West Lancashire Borough Council

Your ref: 2021/1064/FUL
Our ref:
Date: 4th October 2021

Proposal: Partial change of use and conversion of upper storey and rear of disused bank into student accommodation. Demolition of extension to rear and construction of small outrigger. Internal reconfiguration of commercial ground floor unit.

Location: 9A Derby Street, Ormskirk, Lancashire

Proposed Site Plan

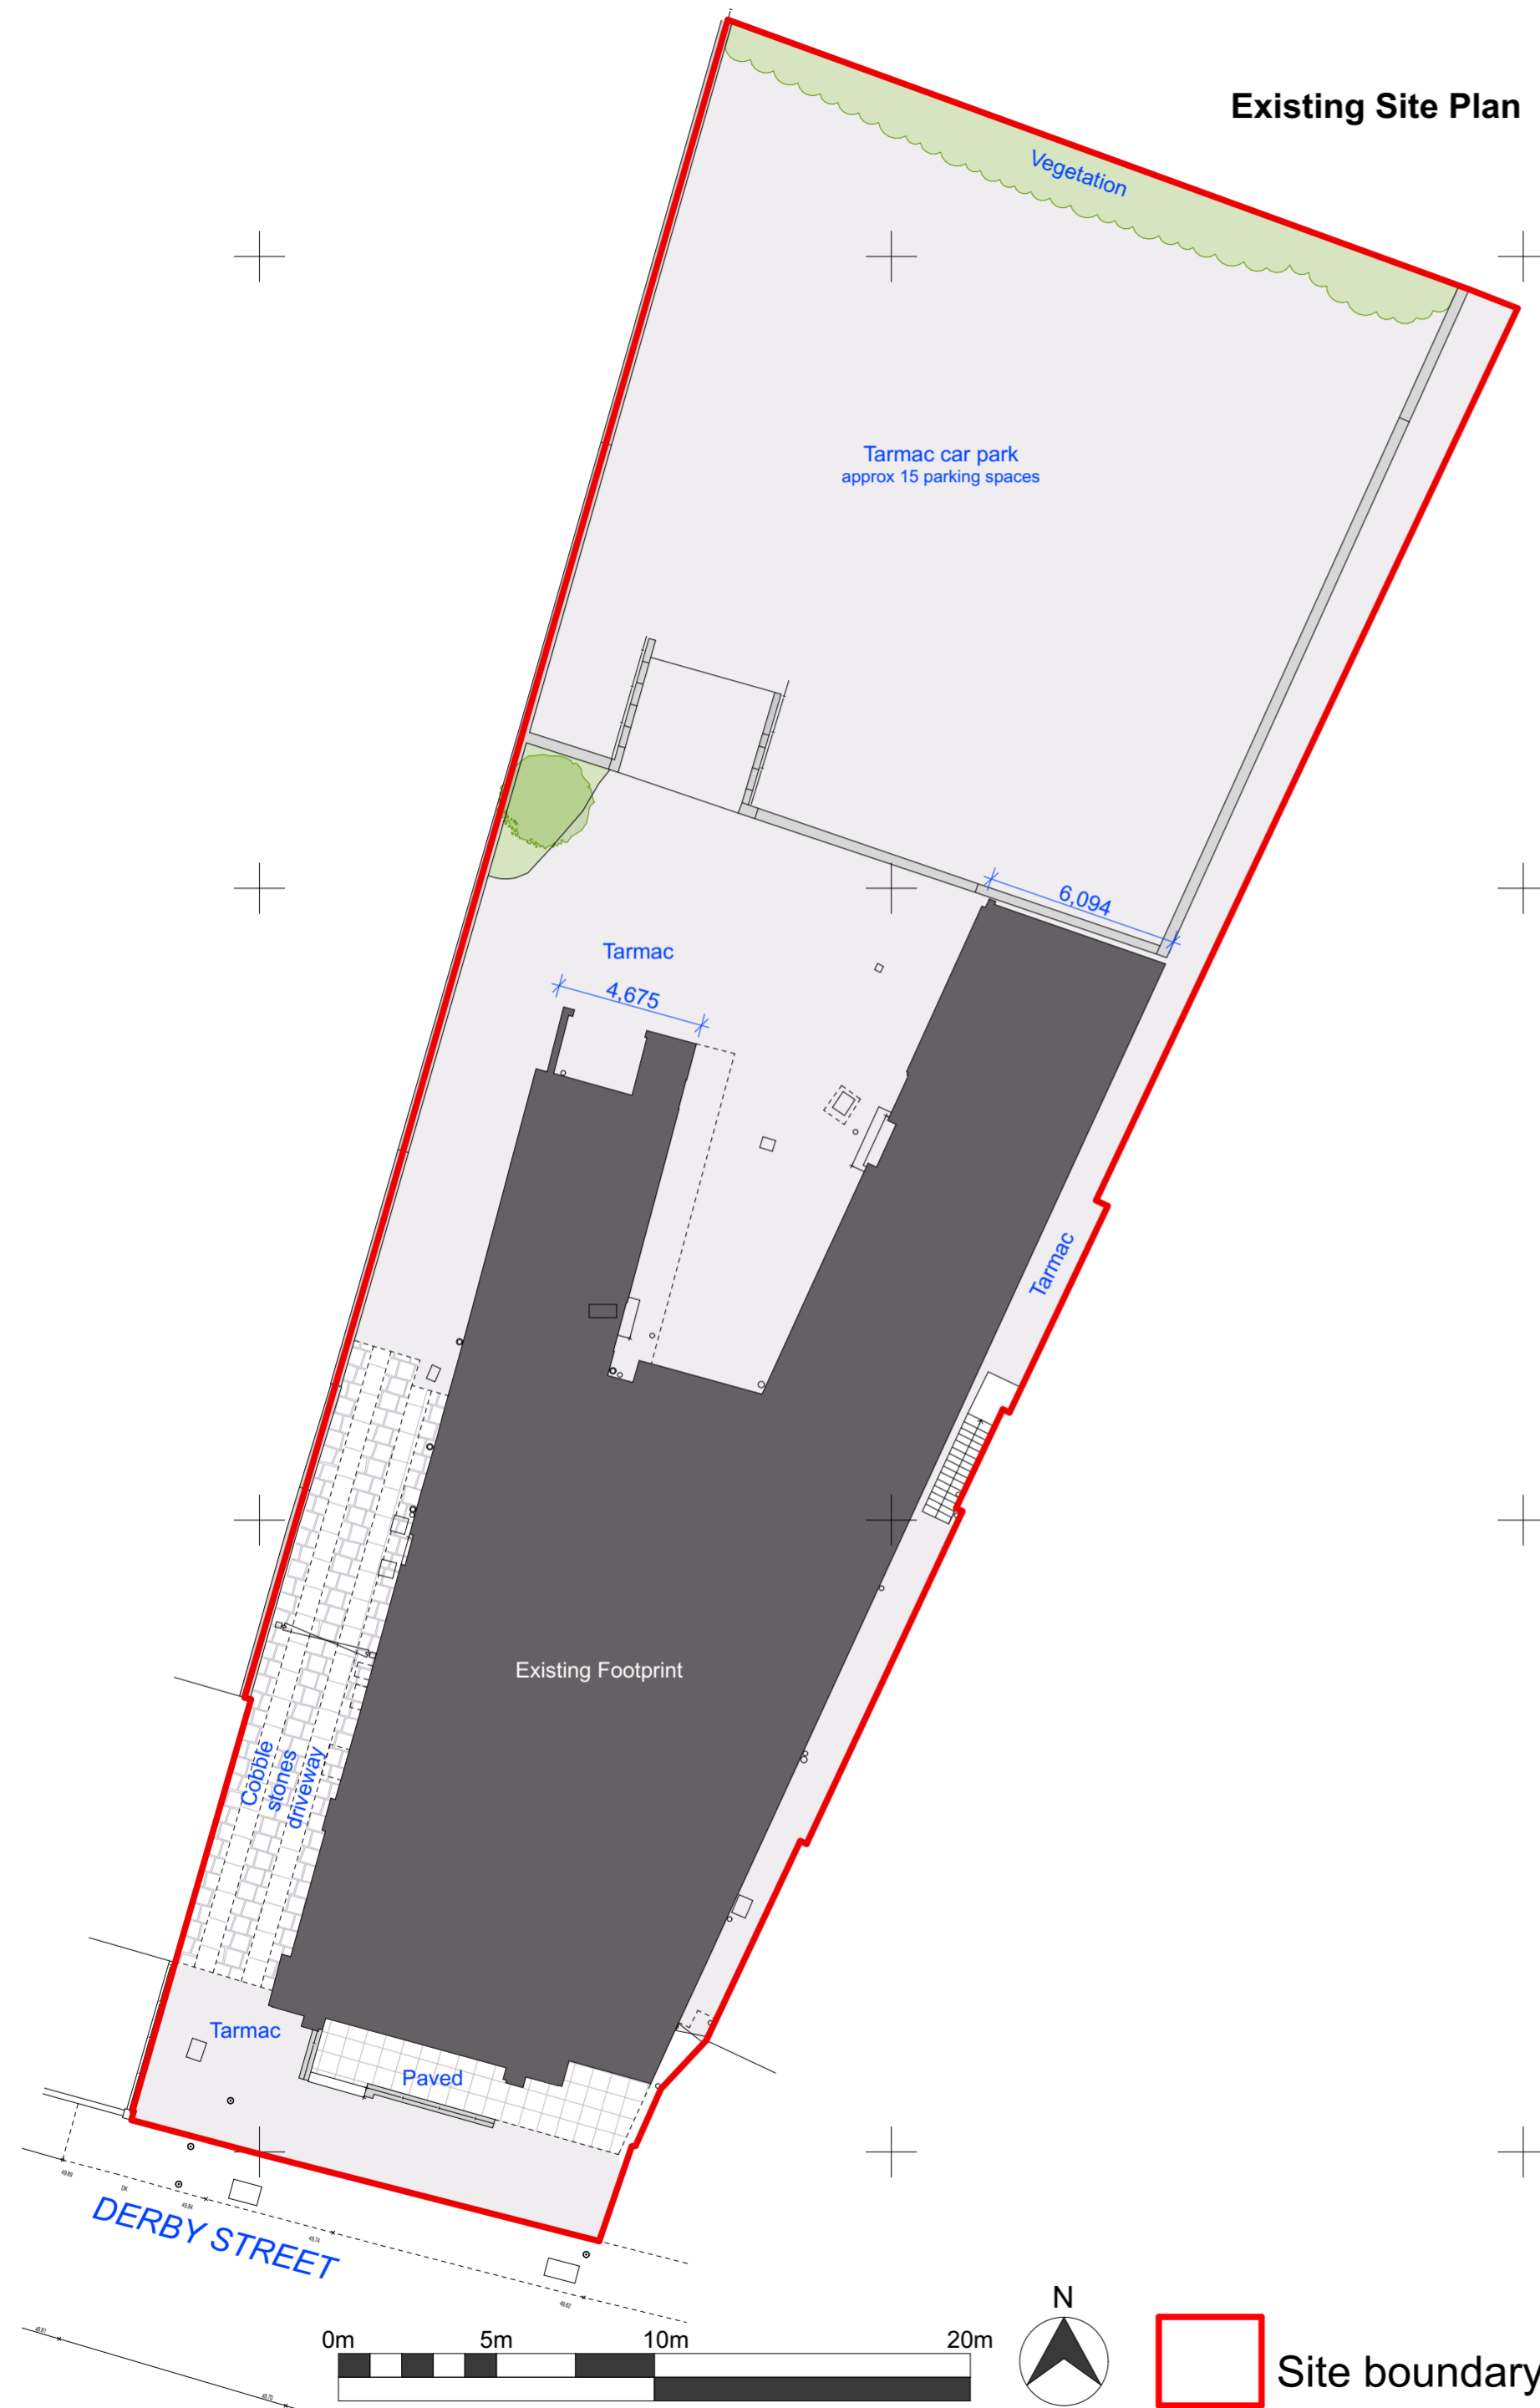
The submitted plans indicate that 15 car parking spaces will be provided for the proposed student accommodation with an additional 4 spaces provided for use by the commercial unit. A covered cycle shelter for 8 cycles has been indicated to the rear of the property within a secure yard.

I would request that West Lancashire Borough Councils waste management team are consulted regarding the location of the proposed refuse storage area and on the arrangements for collection.

2. The car parking and manoeuvring scheme to be marked out in accordance with the approved plan, before the use of the premises hereby permitted becomes operative and permanently maintained thereafter. Reason: To allow for the effective use of the parking areas.
